From: Joe Seemiller <seemillerj@kvfr.org>
Sent: Monday, January 30, 2017 11:05 AM
To: Dusty Pilkington
Cc: RichElliott; John Sinclair; Josh Hink
Subject: FW: BL-17-00017 Crowley

From: Dusty Pilkington [<mailto:dusty.pilkington@co.kittitas.wa.us>]
Sent: Monday, January 30, 2017 10:04 AM
To: Kelly Bacon; Holly Duncan; Holly Myers; Josh Hink; Lucas Huck; Rich Elliott; Dr. Paul Farris, Ellensburg School District; fwalker@eburg.wednet.edu; Karen Hodges
Subject: BL-17-00017 Crowley

Site Plan
Existing

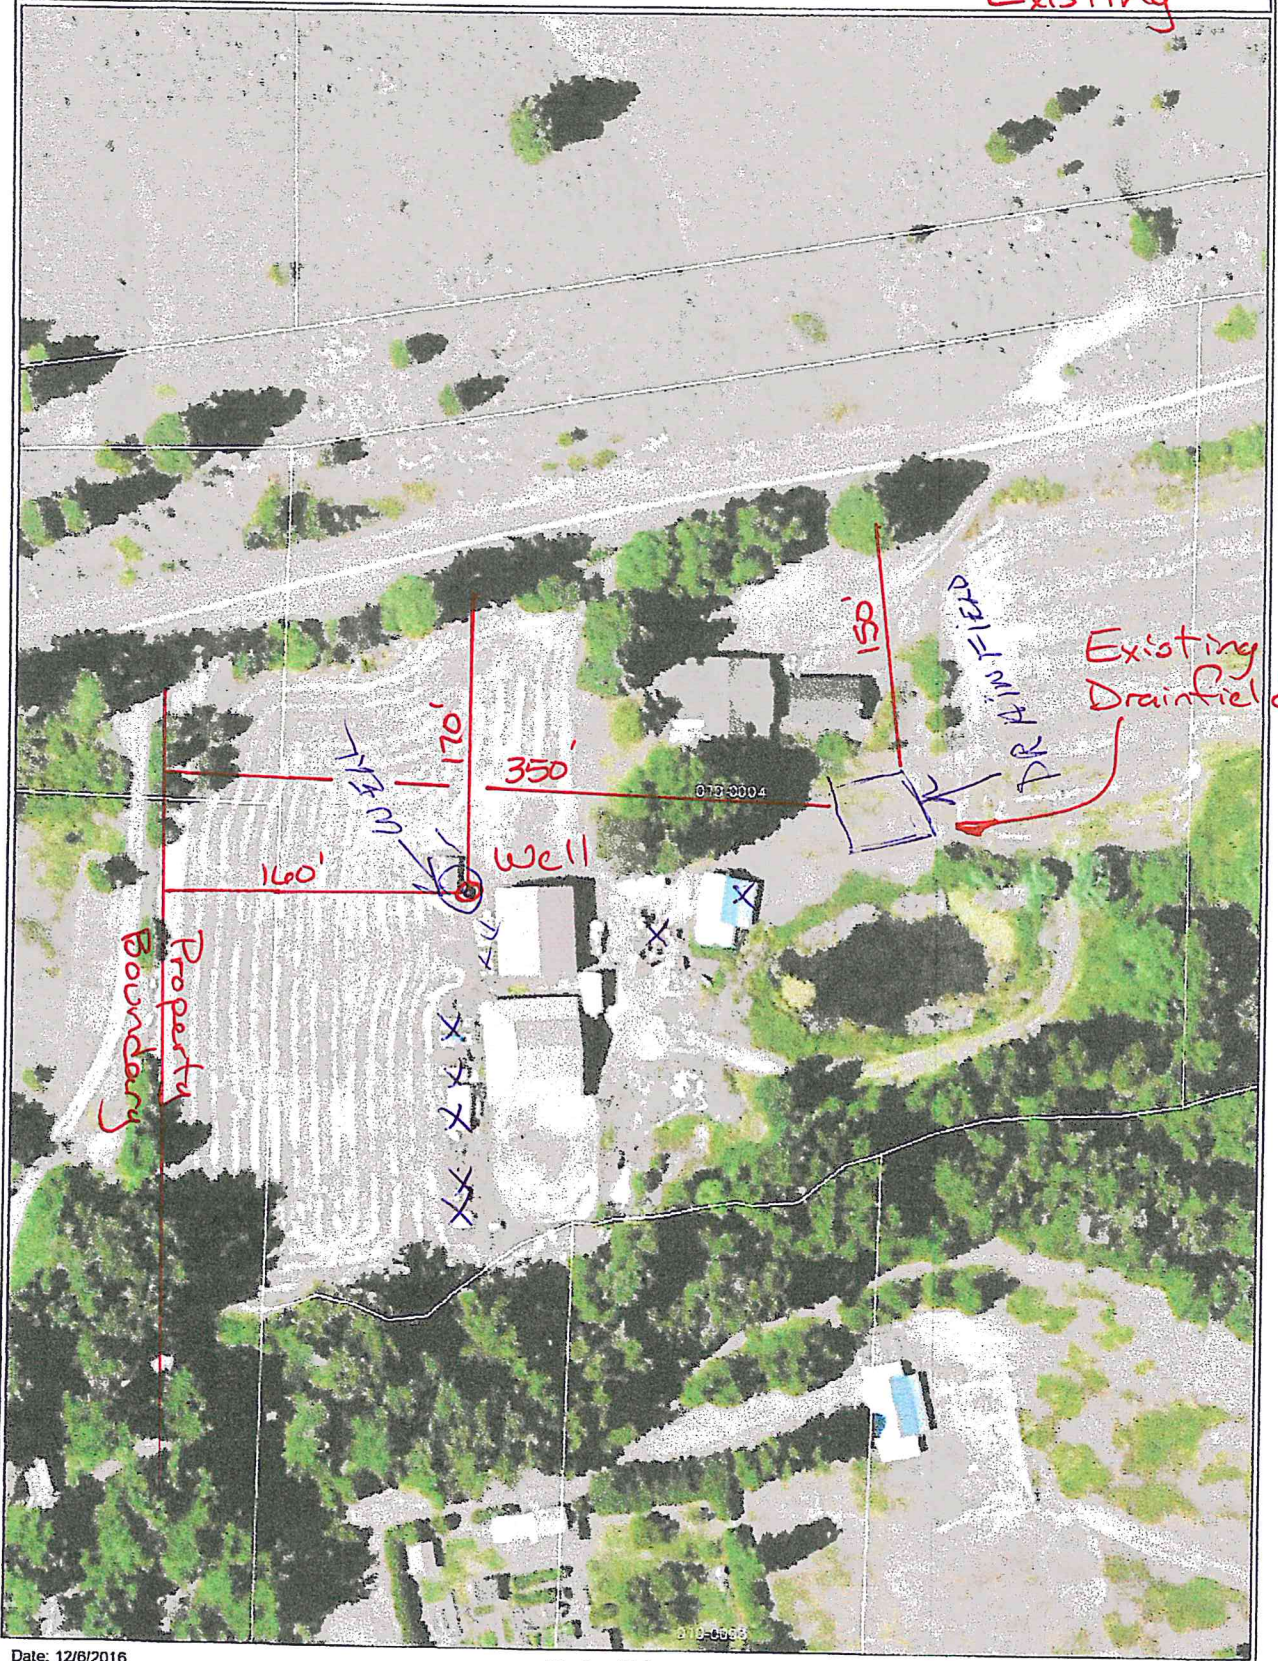
Since no building is being proposed I would have to agree with Chief Elliott. However I do have a concern with the northern parcel. The existing driveway is not adequate for emergency vehicle access. Since this access is, at least for now, intended to be utilized as a "driveway" there is not much I can require from the fire code. I think it would be prudent for any future owner to understand the limitations of that driveway for emergency vehicle use. Please contact me with any comments or questions.
